CITY OF ALBUQUERQUE

June 4, 2012

**Re: US New Mexico Federal Credit Union
Tract 5, Andalucia at La Luz
Conceptual Grading and Drainage Plan
Engineer's Stamp Date 5/18/2012 (E12/D015D1)**

Title DRAINAGE PLAN

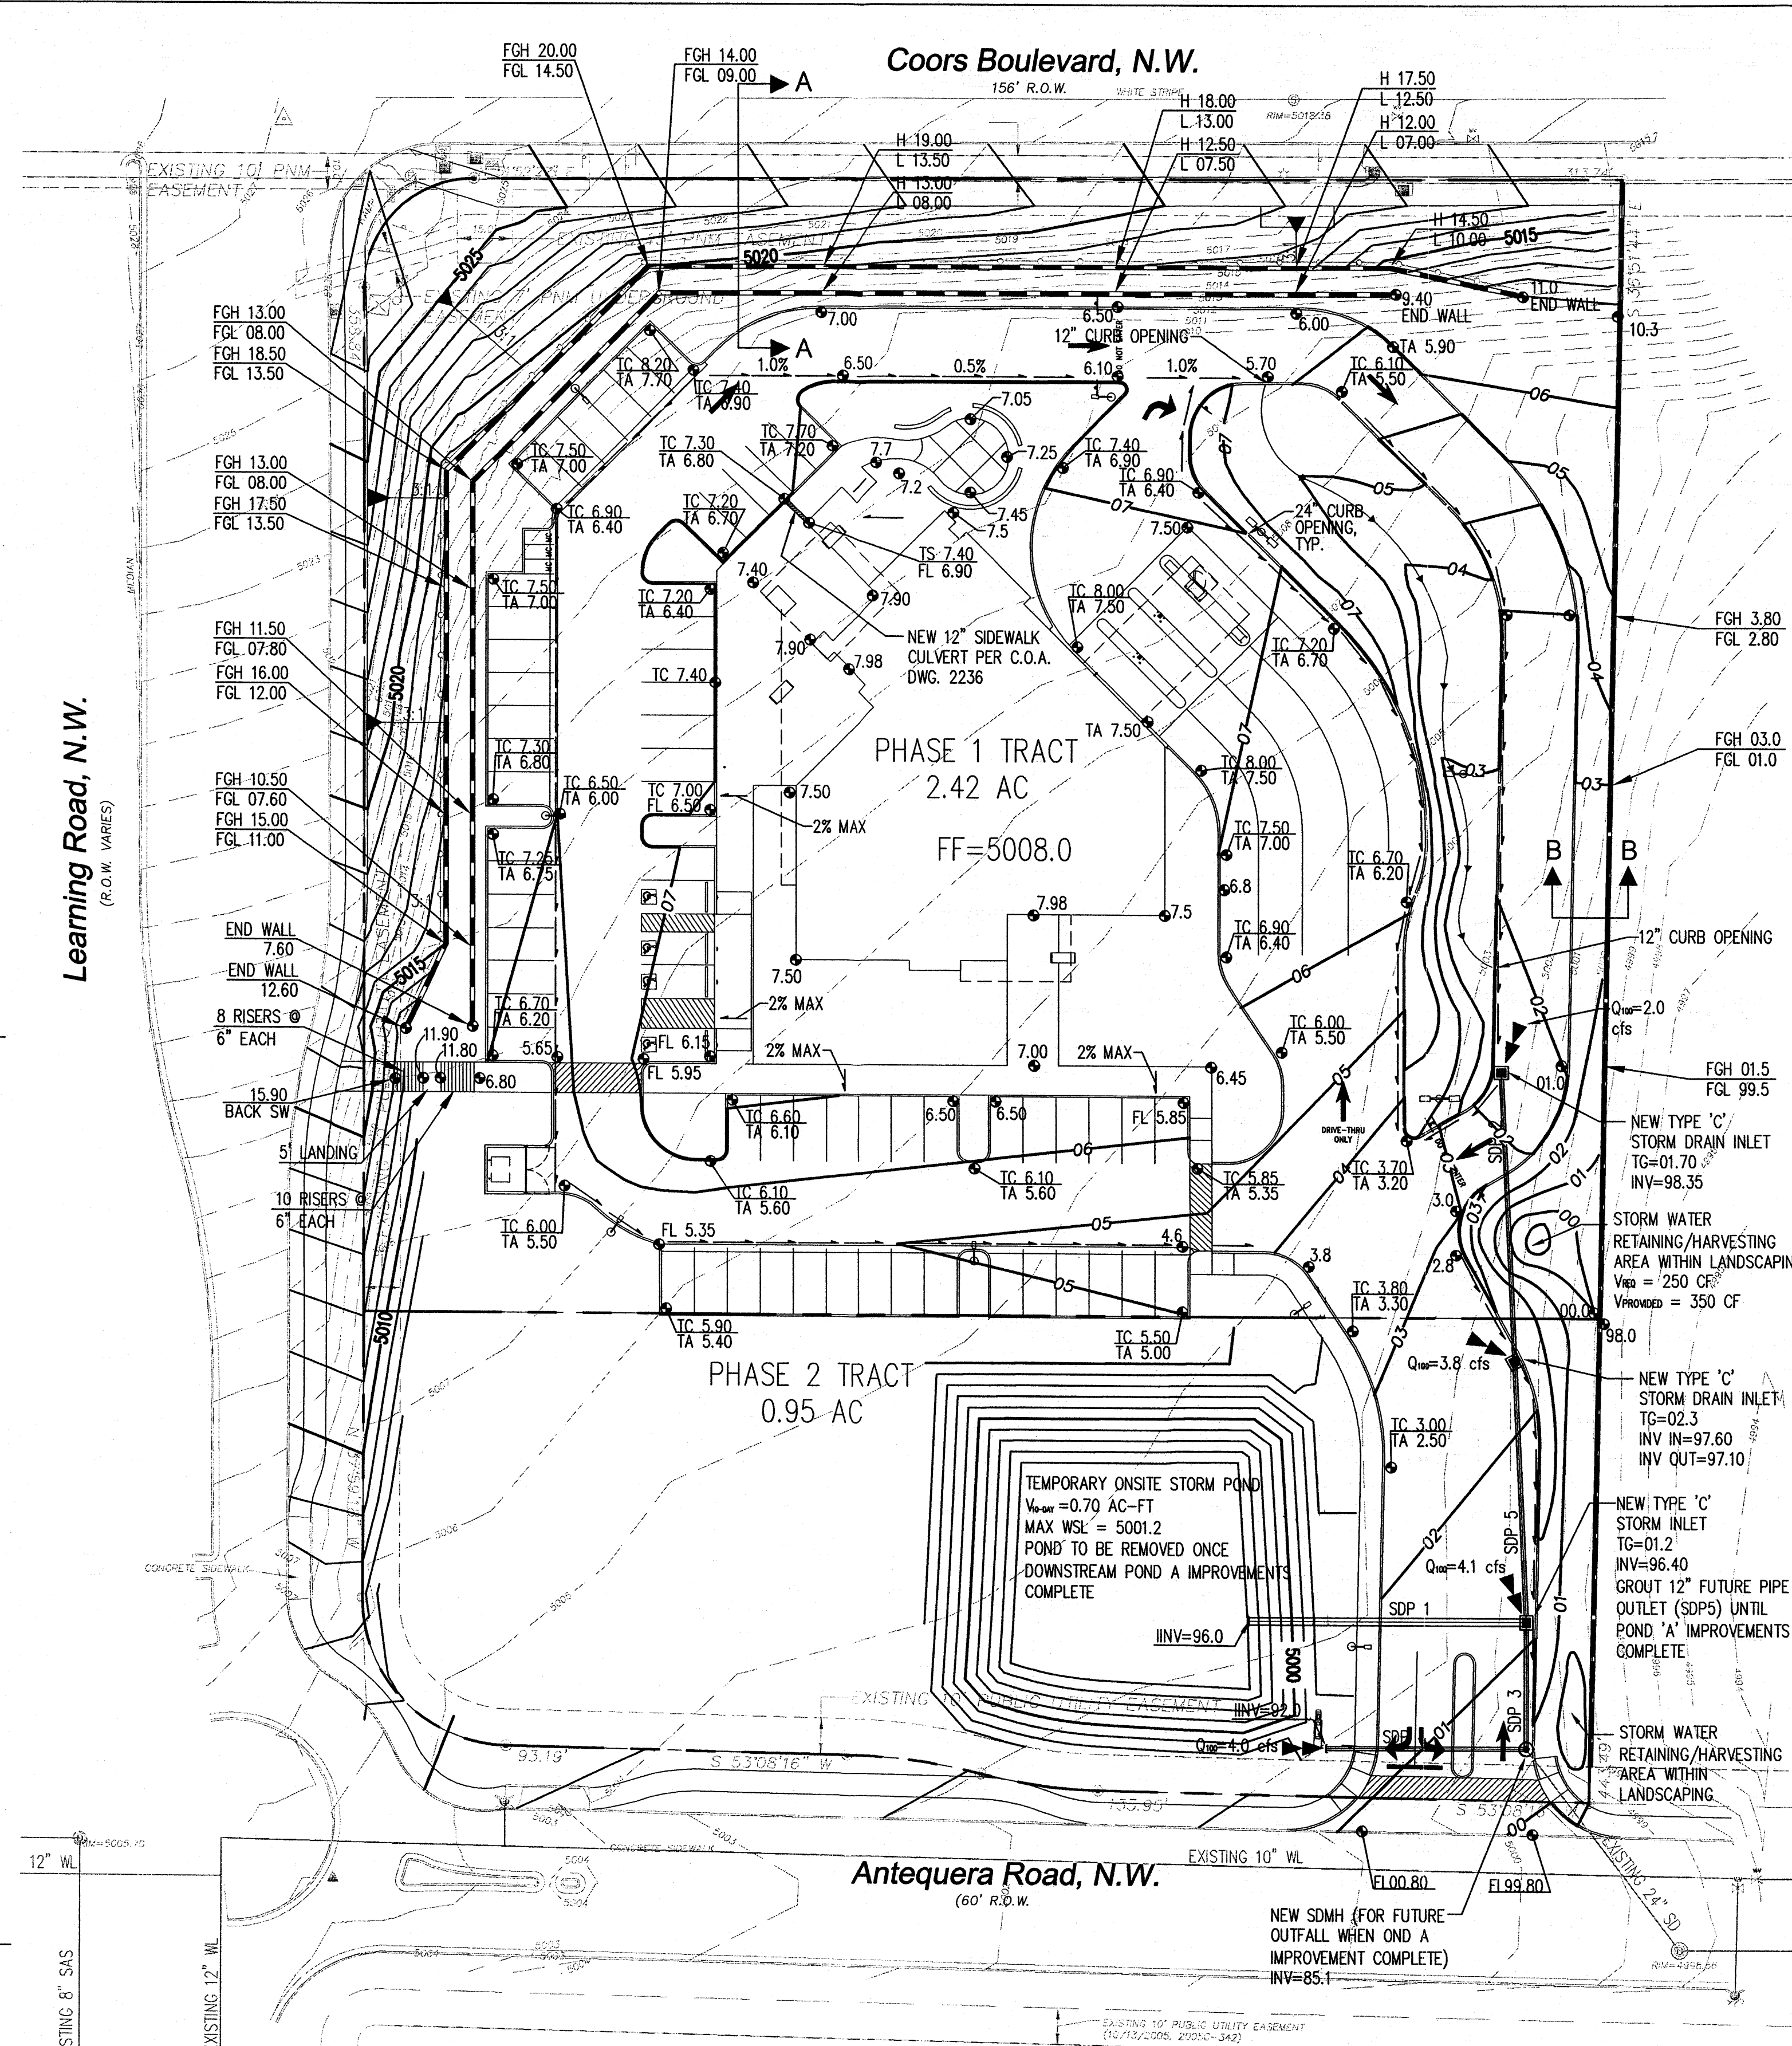
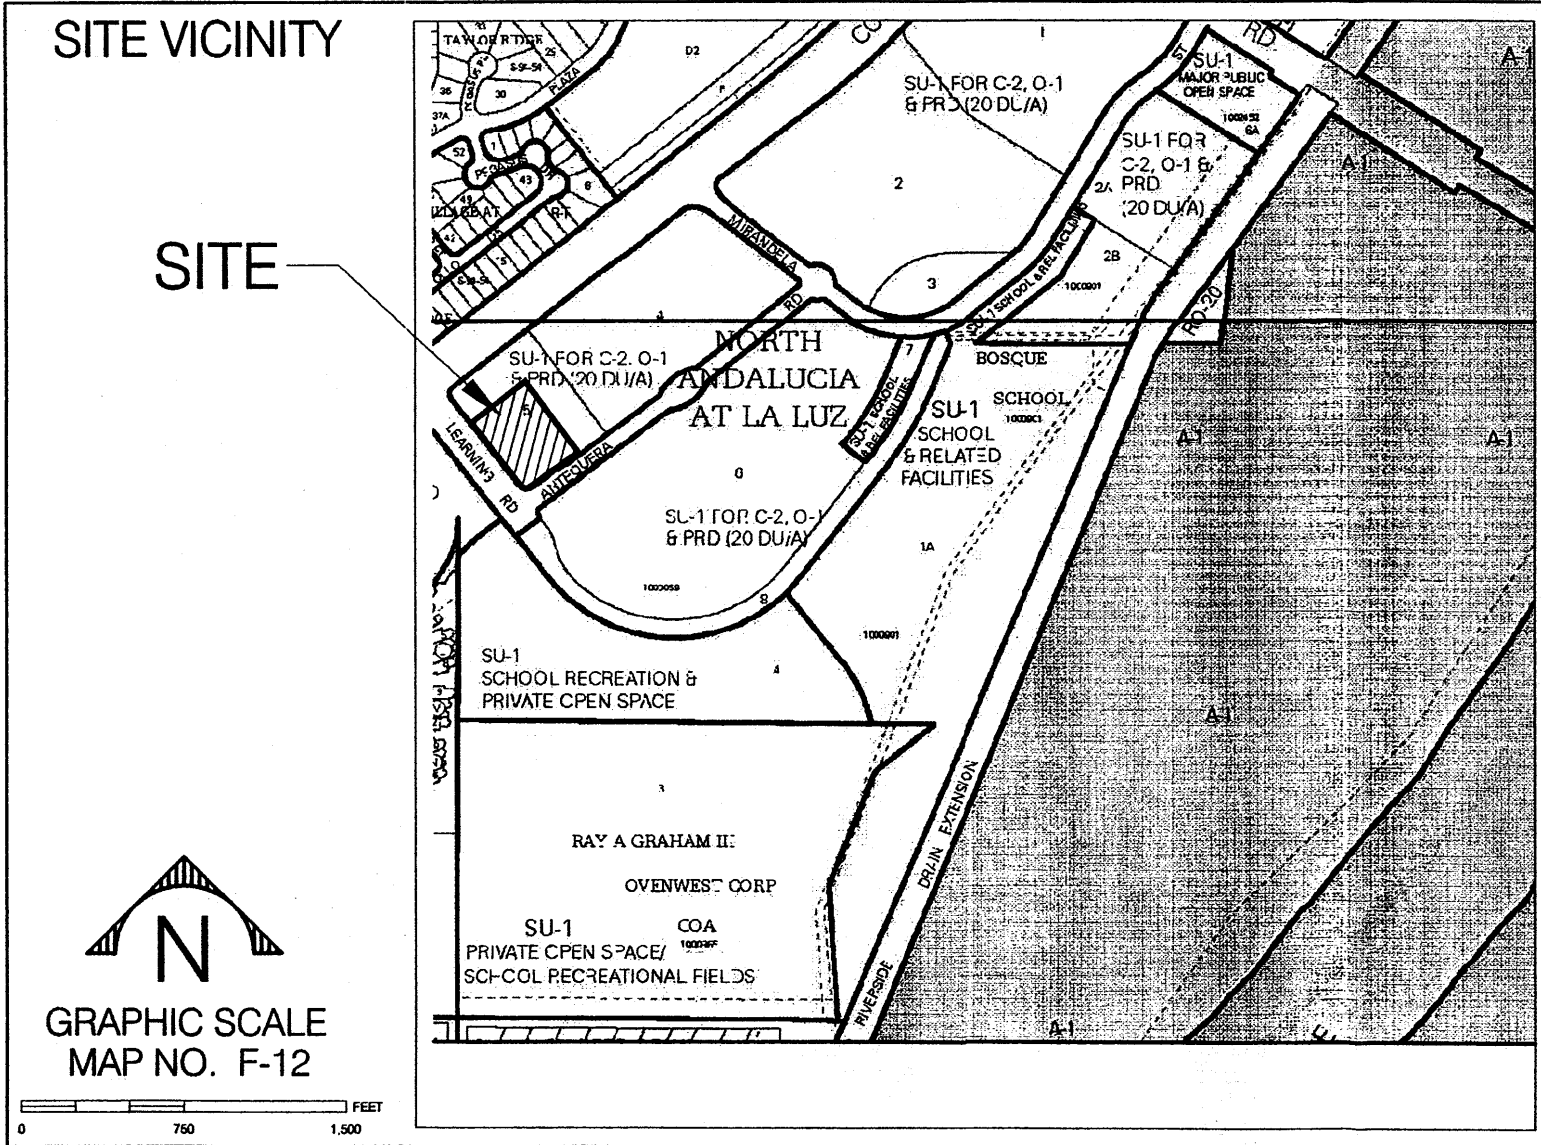
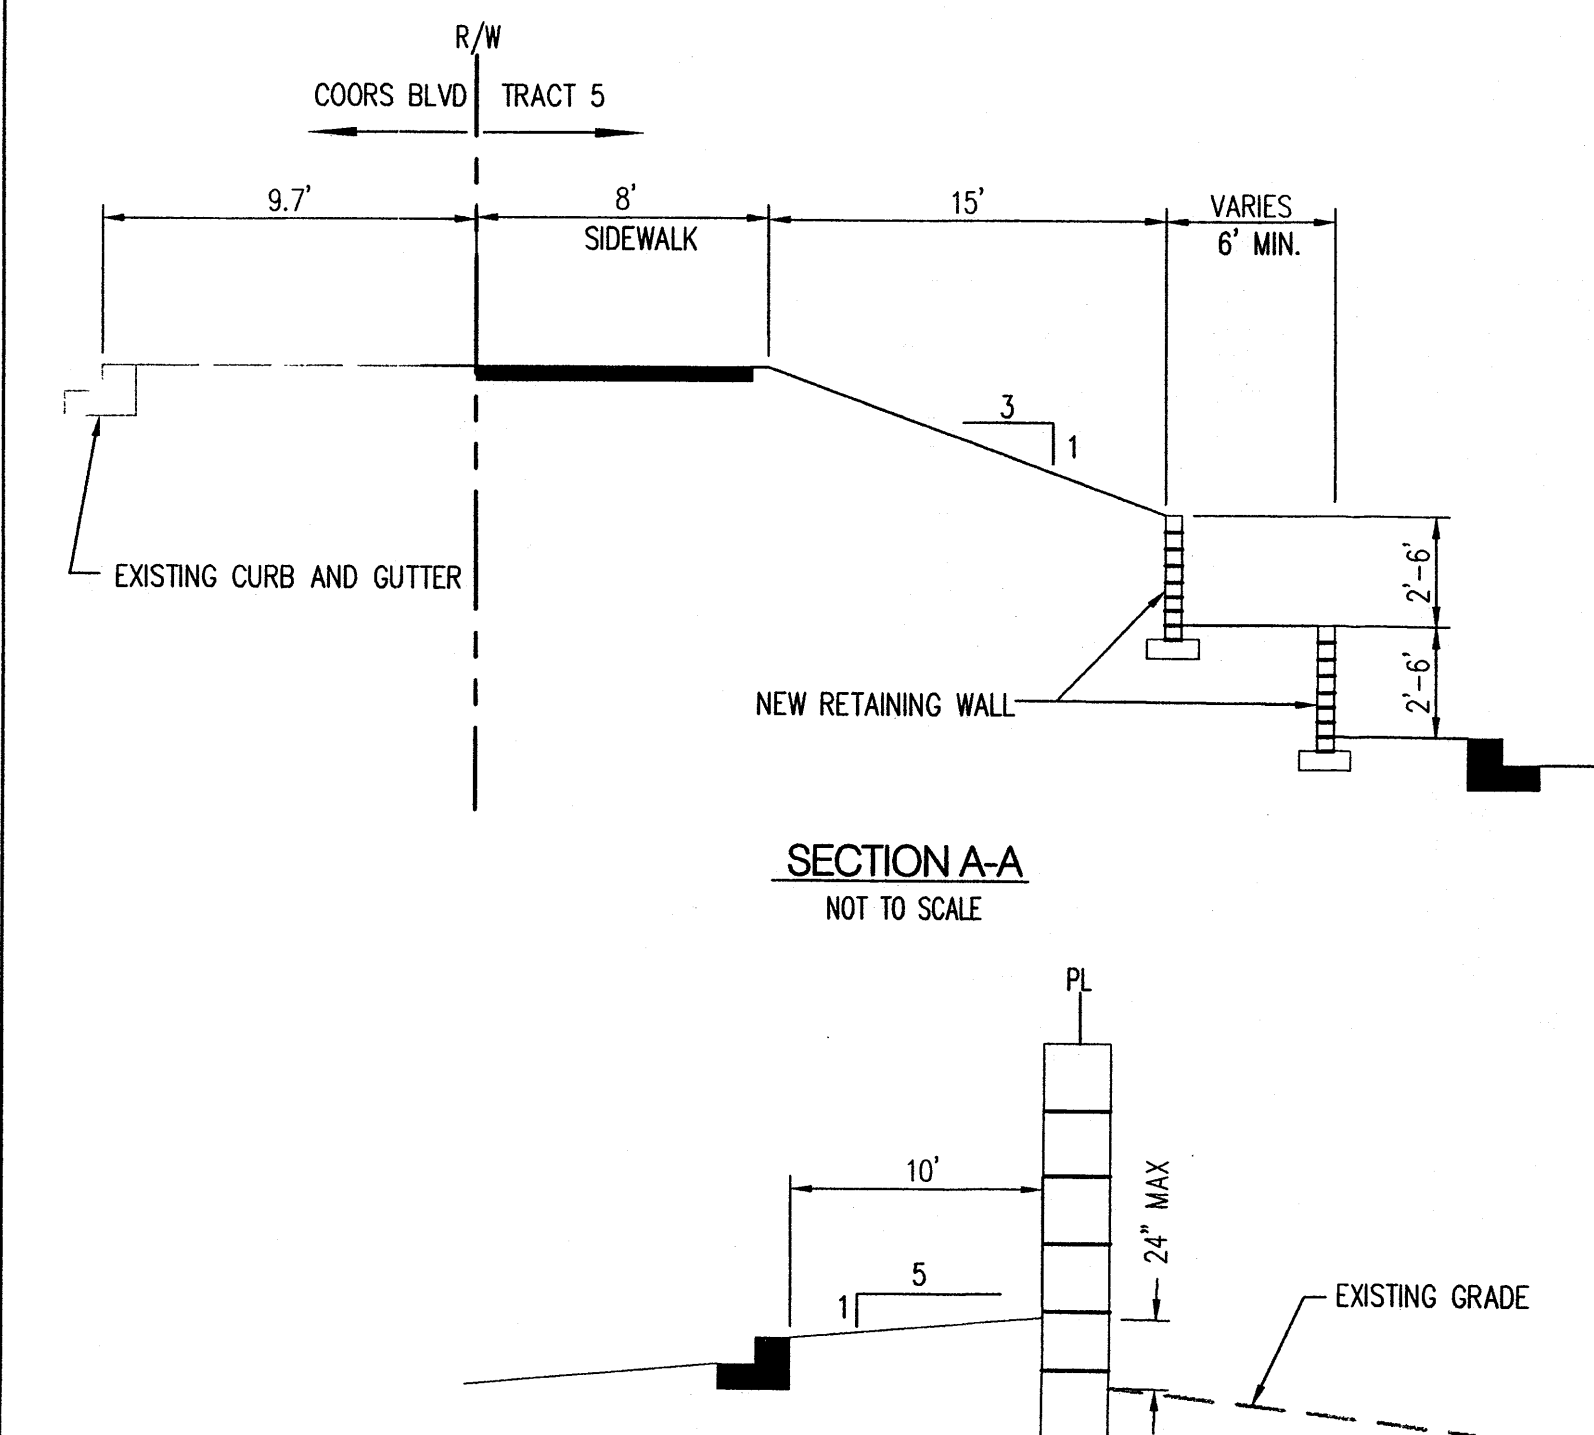
- Pond A has to be modified and as-built grades and volume calculations should be provided.
- If Pond A will not be modified the proposed temporary retention pond has to be in place along with the recorded drainage easement.
- As previously mentioned grout is not a preferred method for plugging the pipe, because there is the possibility of debris in the downstream public storm drain.
